Our ref: SSD 5169 MOD2, 12/03480

**Horsley Drive Business Park Subdivision and Infrastructure Works (SSD 5169) – MOD2  
Response to Submissions**

**HORSLEY DRIVE BUSINESS PARK – SSD 5169 MO1– REQUEST FOR MODIFICATION**

DEVELOPED ELEVATION - RETAINING WALL 6
 SCALE 1:250
 UPPER TIER WALL S.A. = 996 sqm
 MIDDLE TIER WALL S.A. = 737 sqm
 LOWER TIER WALL S.A. = 310 sqm

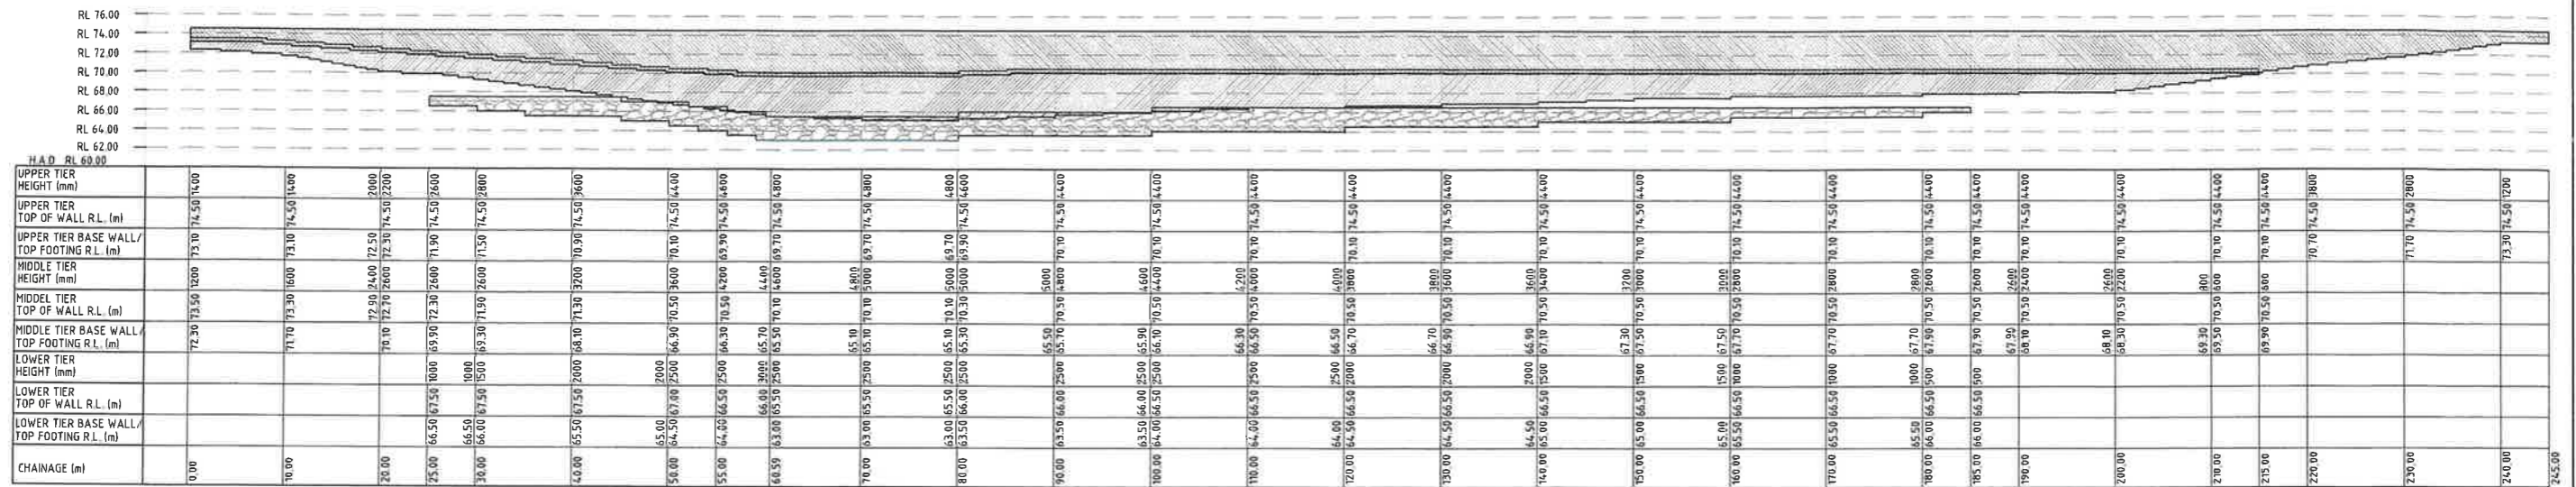
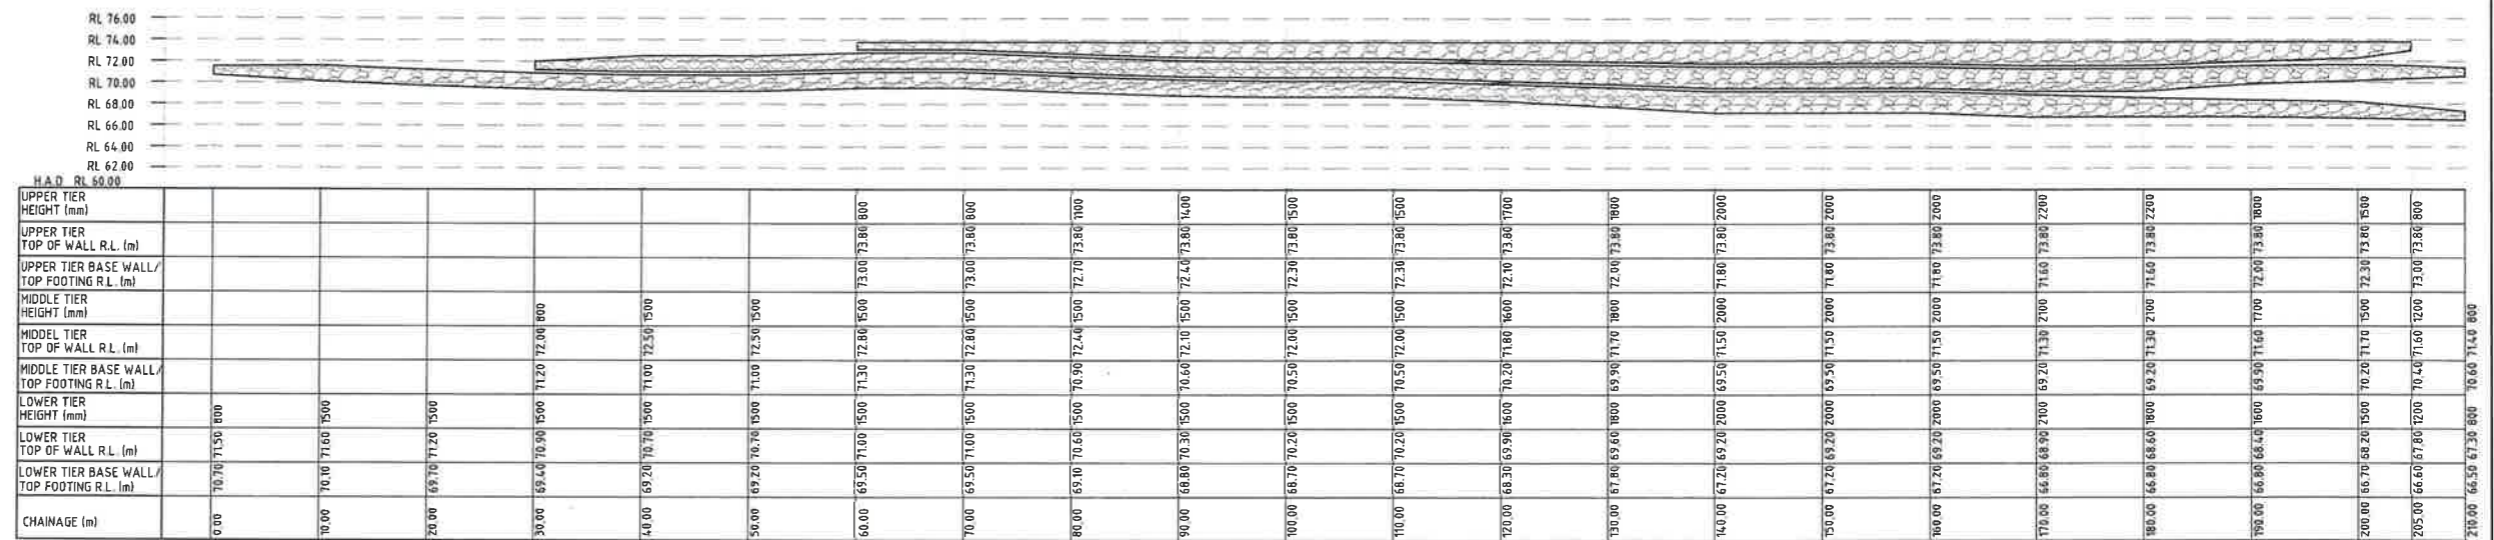
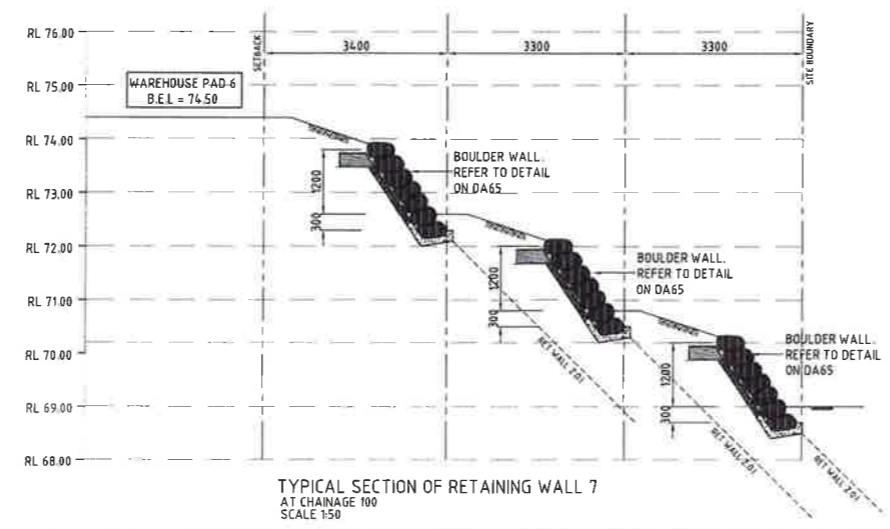
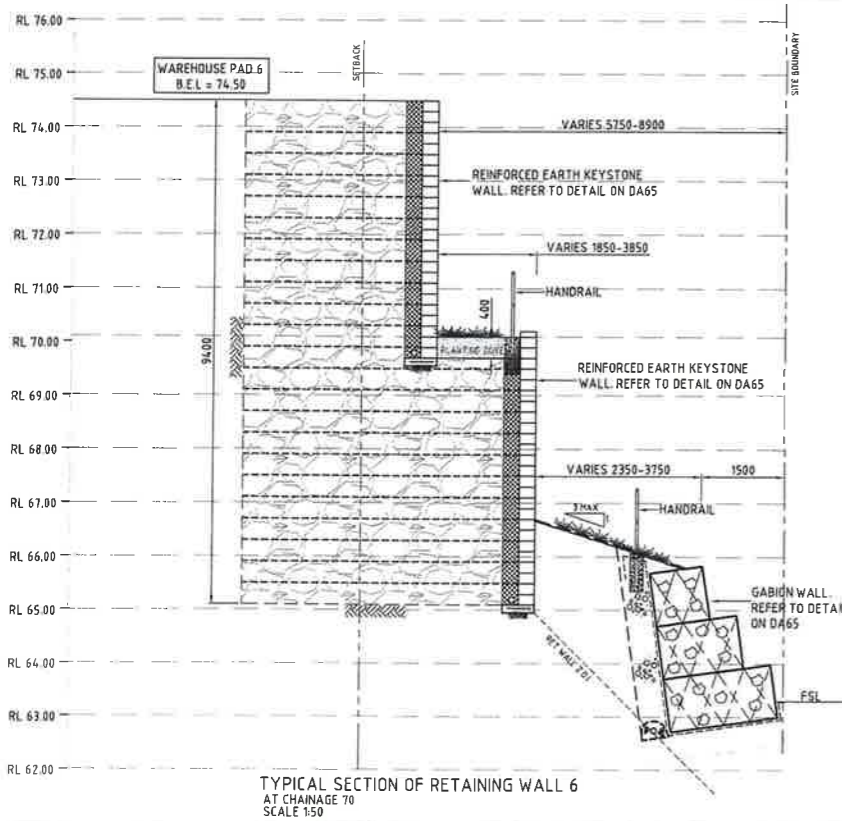
- The applicant needs to provide additional measures to reduce the bulk and scale of the proposed retaining walls. This includes addressing the need for additional soft landscaped areas, details of the location and depth of planting within the retaining walls.
- The finish of the retaining walls should have a more 'natural' appearance having regard to the setting of the site within the Western Sydney Parklands and gateway position to the Wetherill Park.
- The applicant needs to provide more detailed information including fully dimensioned plans and levels regarding the above.
- The applicant should substantiate as to why the proposed excessive height of the modified retaining walls is able to be dealt as a minor modification under s.96(1A) the EP&A Act
